Town & Country Planning Act 1990 (as amended)
Town and Country Planning (Development Management Procedure) (England) Order 2015
Application for approval of details reserved by condition imposed on planning permission
WA/28/14/PL relating to condition 10 (Travel Plan Statement) and 13 (Entrance gates)
Walberton Place Care Home Yapton Lane, Walberton,

Condition Number 13

Arun District Council have decided to **REFUSE details reserved by condition for the following reasons:**

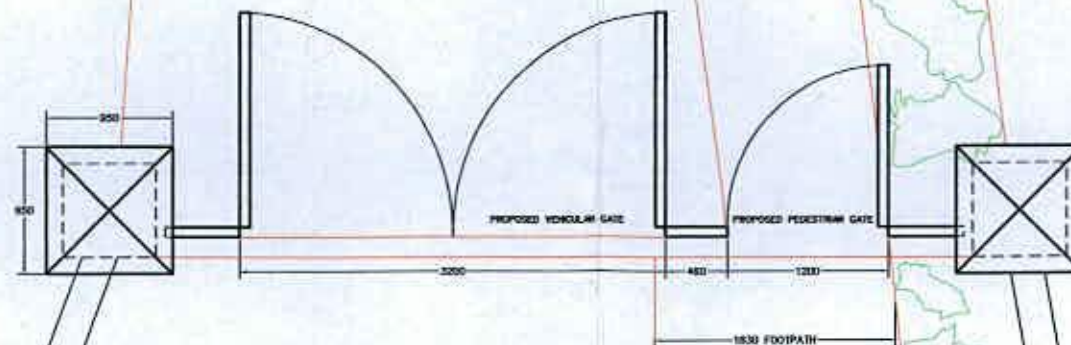
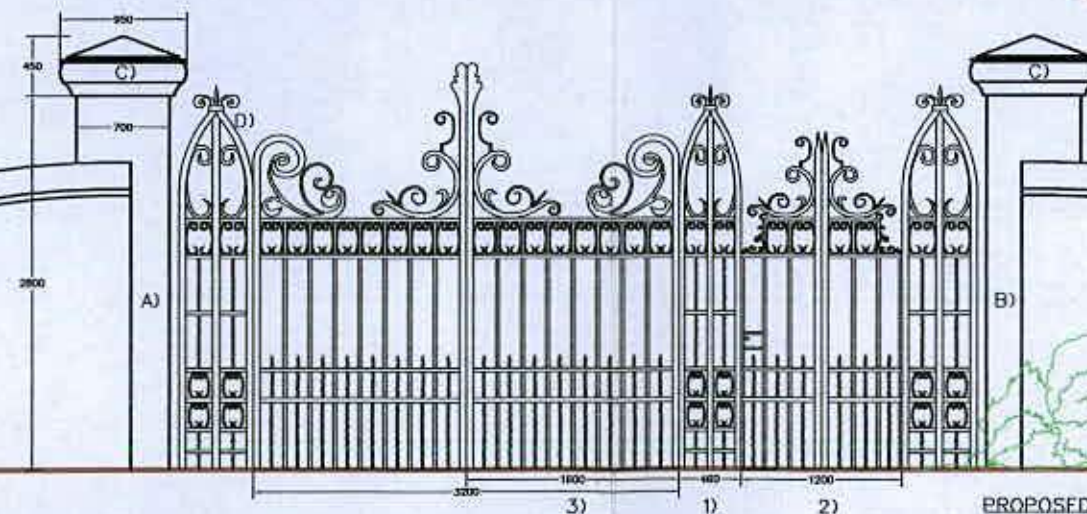
This condition cannot be discharged. Two options have been provided as part of the submission and it is not clear which is the preferred approach.

The gates should reflect their historic appearance in order to maintain their significance. The second option would therefore be the most appropriate.

However, the existing gates are proposed to be powder coated as part of the works and this would damage the historic fabric that should be preserved. The preference would be to clean and paint the existing fabric.
